CITY OF ALBUQUERQUE

Re: The Learning Experience
4580 Nunzio Ave. NW
30-Day Temporary Certificate of Occupancy
Transportation Development Final Inspection
Engineer's Stamp dated 9-17-20 (C12-D003C)
Certification dated 02-15-22

Based upon the information provided in your submittal received 02-15-22, Transportation Development has no objection to a 30-day Temporary Certificate of Occupancy based. This letter serves as a "green tag" from Transportation Development for a 30-day Temporary Certificate of Occupancy to be issued by the Building and Safety Division.

THE LEARNING EXPERIENCE  
SITE PLAN - TRAFFIC CIRCULATION PLAN

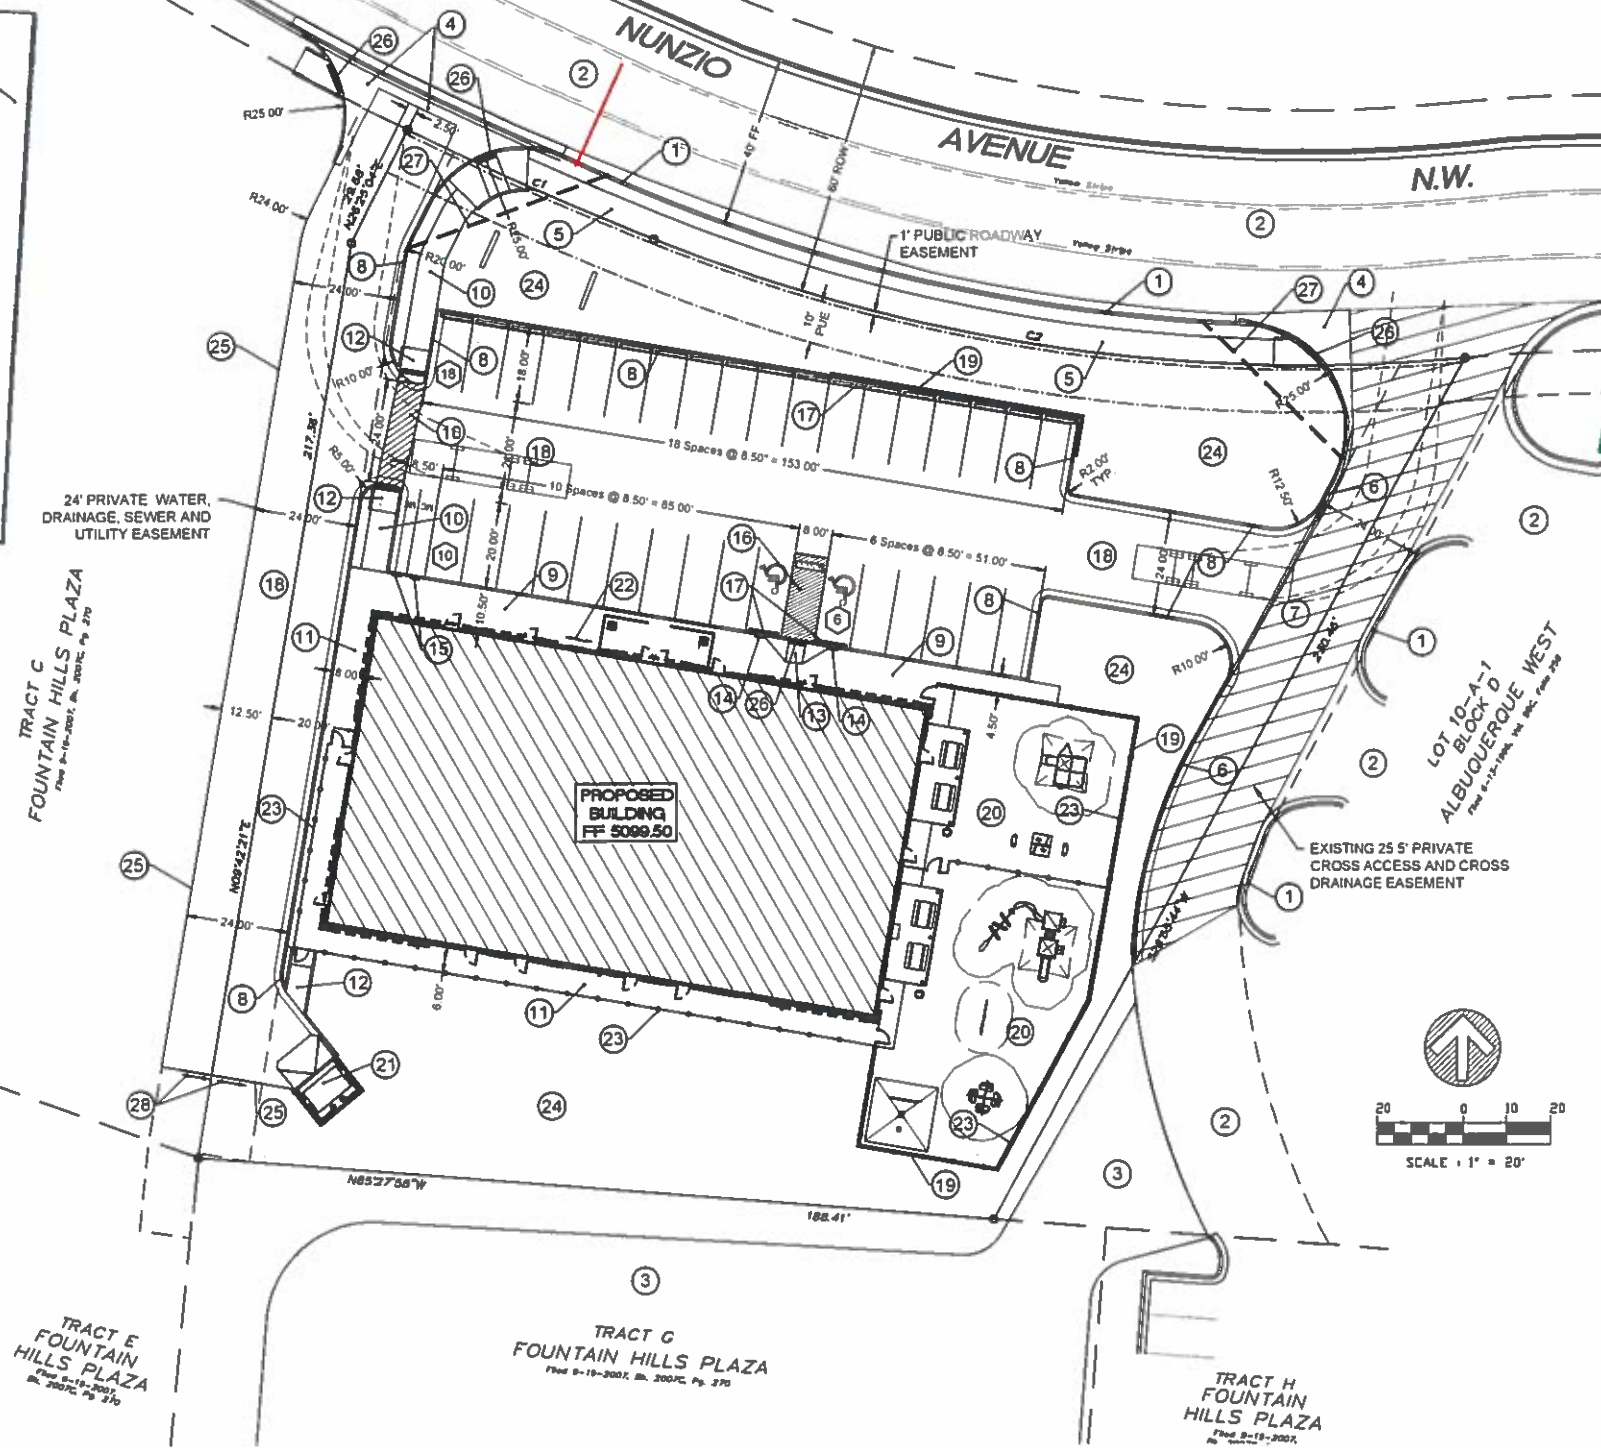
- The missing section of the public sidewalk needs to be constructed prior of release the final CO.
- Tripping hazard on pedestrian pathway from public sidewalk. 2 of Concretes' pieces are not even. (located by the fire hydrant). Please fix this issue.
- The width of the West side (of parking spaces) driveway access is 22' (please red mark the site plan).

Once these corrections are complete, email pictures & redlined TCL plan showing the changes to PLNDRS@cabq.gov, and malnajjra@cabq.gov for release of Final CO.
